Our Ref: P/21/19/PL

**Town & Country Planning Act 1990 (as amended)
Town and Country Planning (Development Management Procedure) (England) Order 2015
Application for Planning Permission**

Development New dwelling
Location 24 Lion Road Pagham

BLOCK PLAN (1:500)

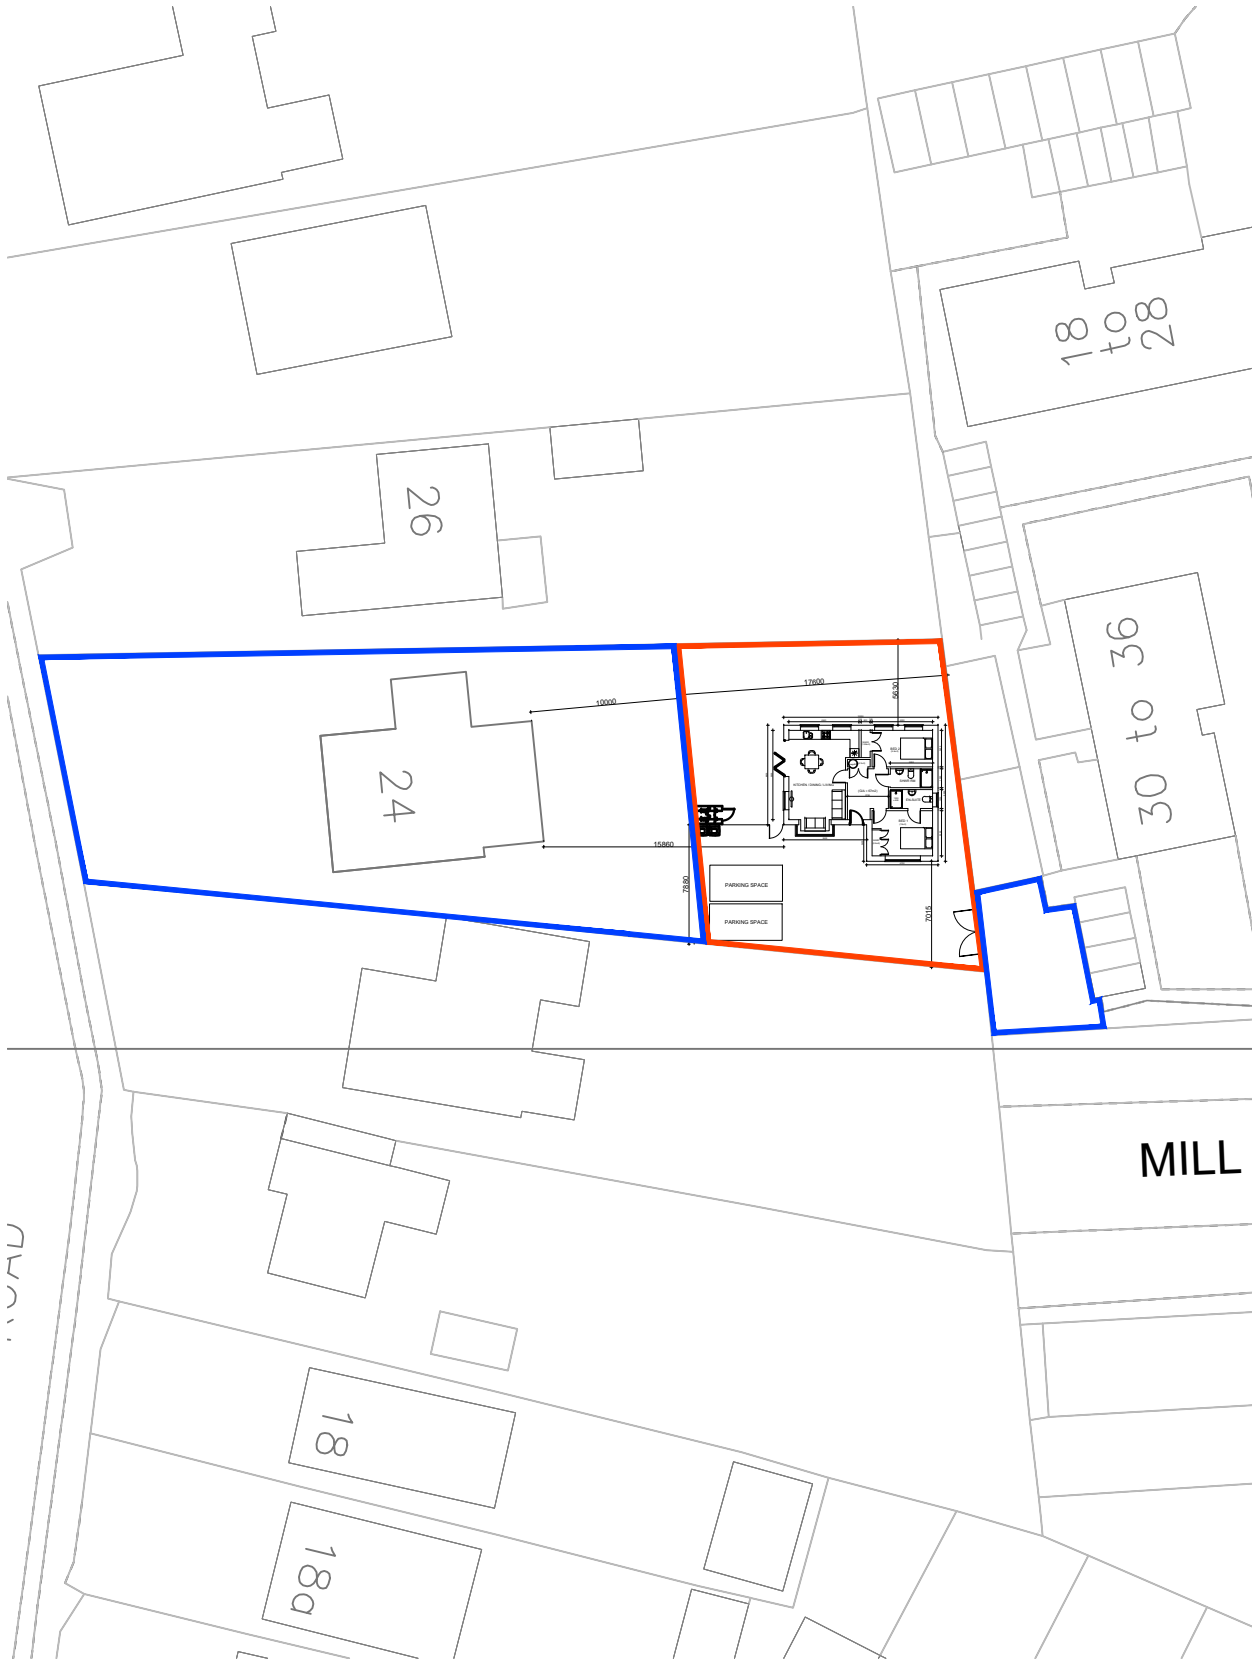
Block Plan

Please submit 1 electronic or 3 paper copies of a block/site plan at a scale of 1:500 or 1:200 to show the access points and visibility splays. Further details of what must be included on the plan can be found in the National Validation Requirements.

-	-	-
REV.	DATE	DESCRIPTION
CLIENT: S. Smith Land rear of 24 Lion Rd, Bognor Regis, West Sussex, PO21 3LA.		
Architectural Services t : 01428 879450 / 01243 767440 w: architectural.uk.com		
DRAWING: Location Plan		
1:1250 0 10 20 30 40 50		
DRG NO. 08/114-004	DATE: 14/12/18	SCALE: A3: 1:1250

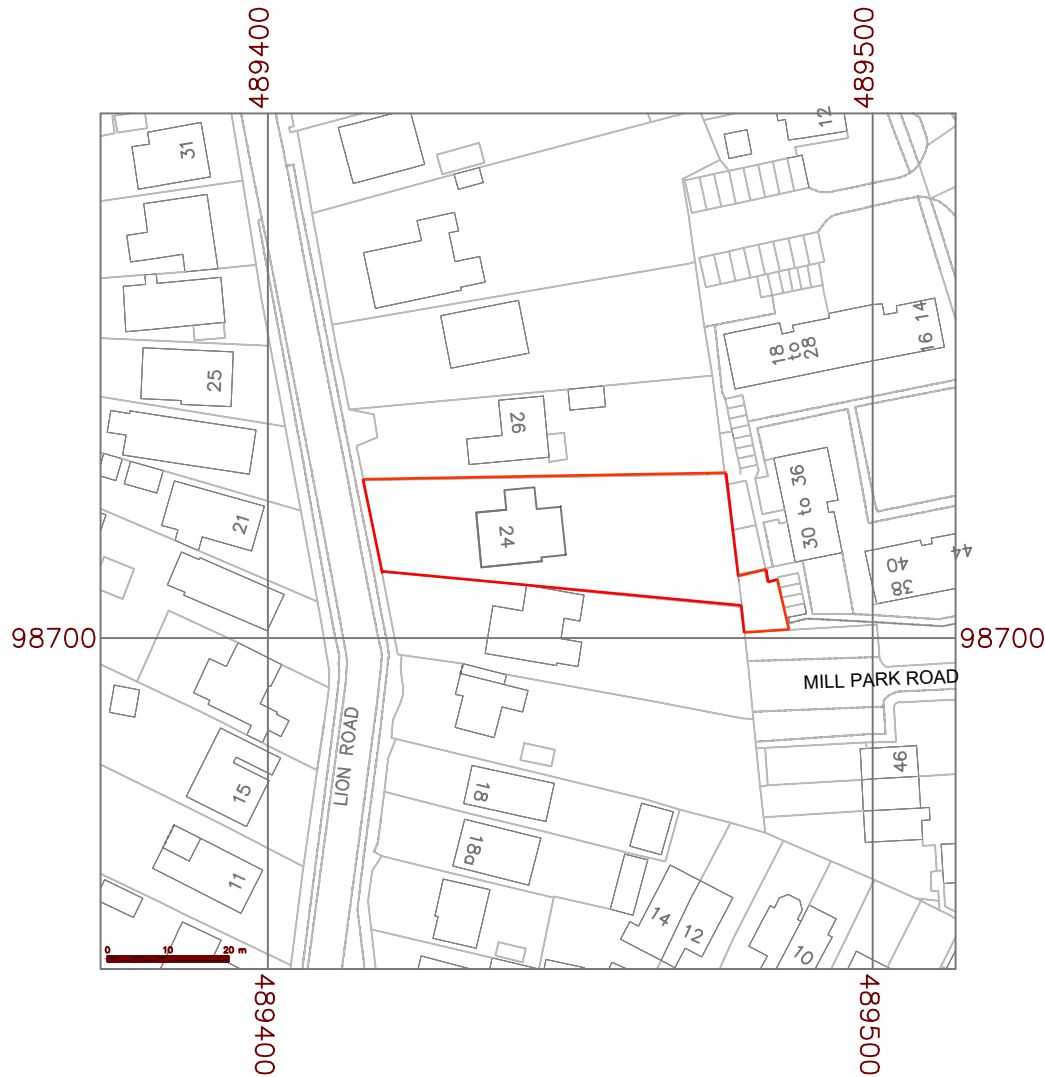
Location Plan

Please submit 1 electronic or 3 paper copies of an amended location plan at a scale of 1:1250 or 1:2500 for rural areas to show the access points and visibility splays. Further details of what must be included on the plan can be found in the National Validation Requirements.
